Our Ref: EP/16/19/HH

**Town & Country Planning Act 1990 (as amended)
Town & country Planning (Development Management Procedure) (England) Order 2015
Application for Planning Permission for Works or Extension to a Dwelling**

Development Single storey rear extension with an addition of a second floor including a rear dormer and gable end window
Location 2 Hillview Crescent East Preston

block plan

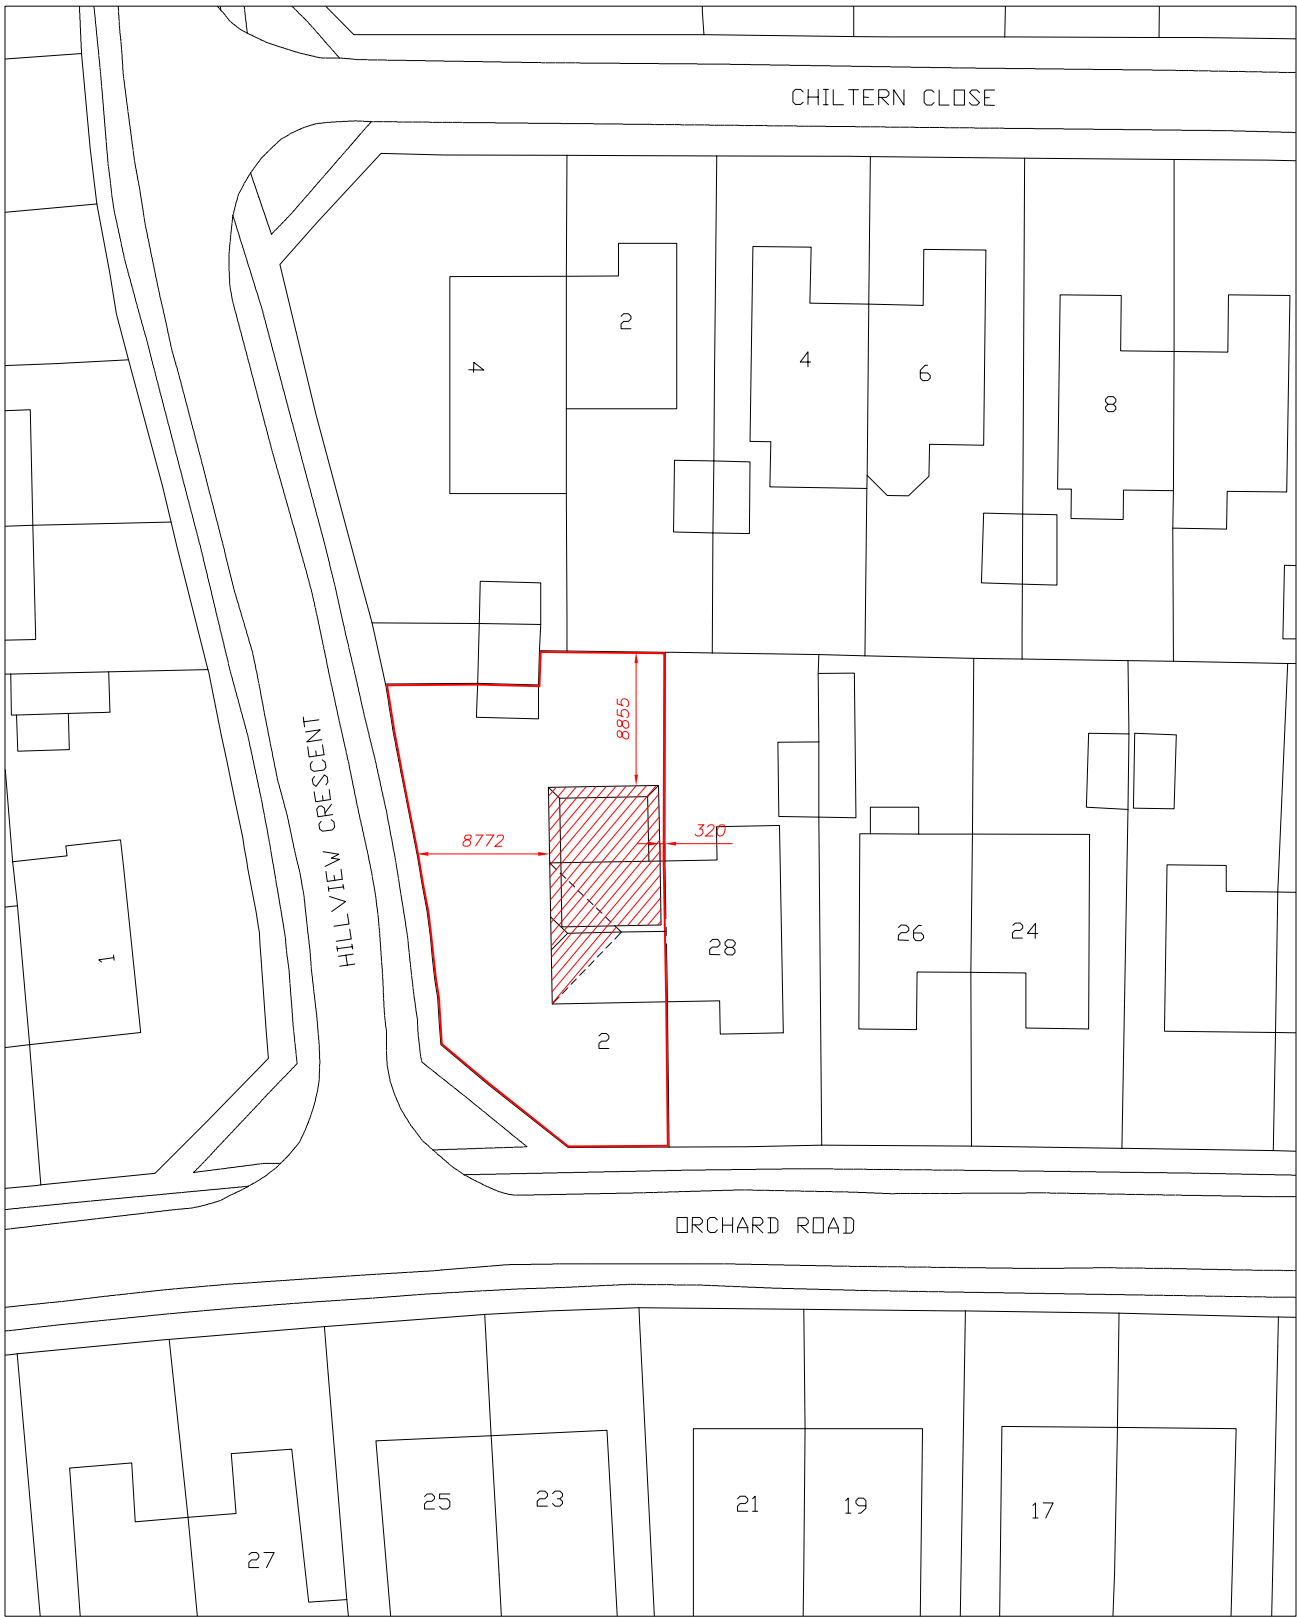
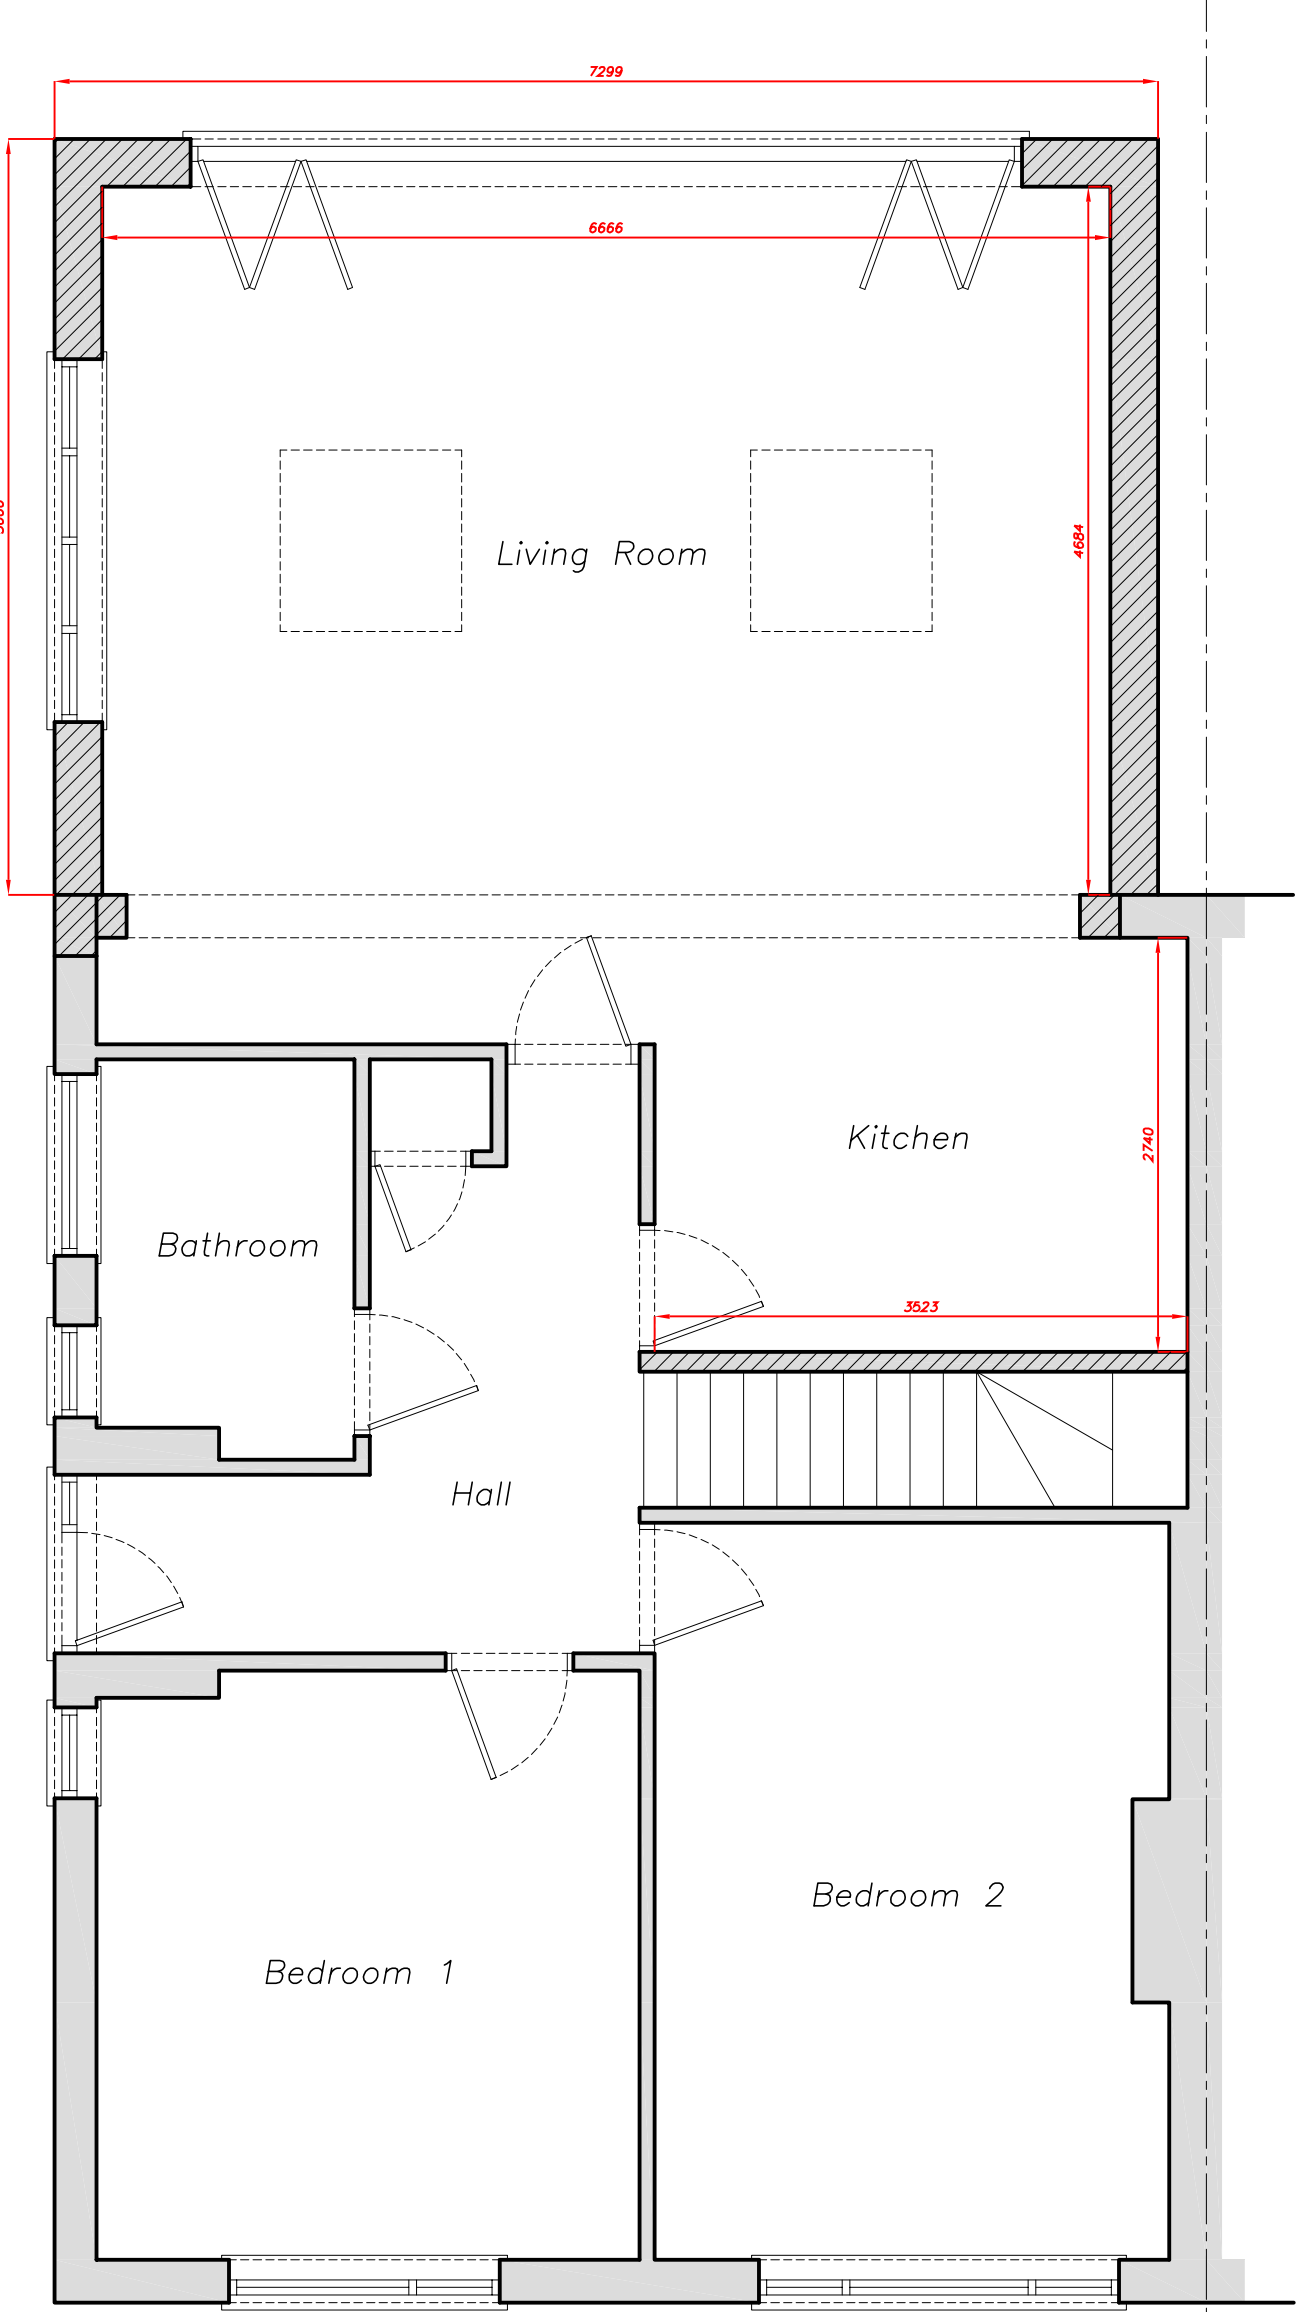
Block Plan

Please submit 1 electronic or 3 paper copies of a block/site plan which includes all the dimensions from the proposed rear extension to the site boundaries at a scale of 1:500 or 1:200. Further details of what must be included on the plan can be found in the National Validation Requirements.
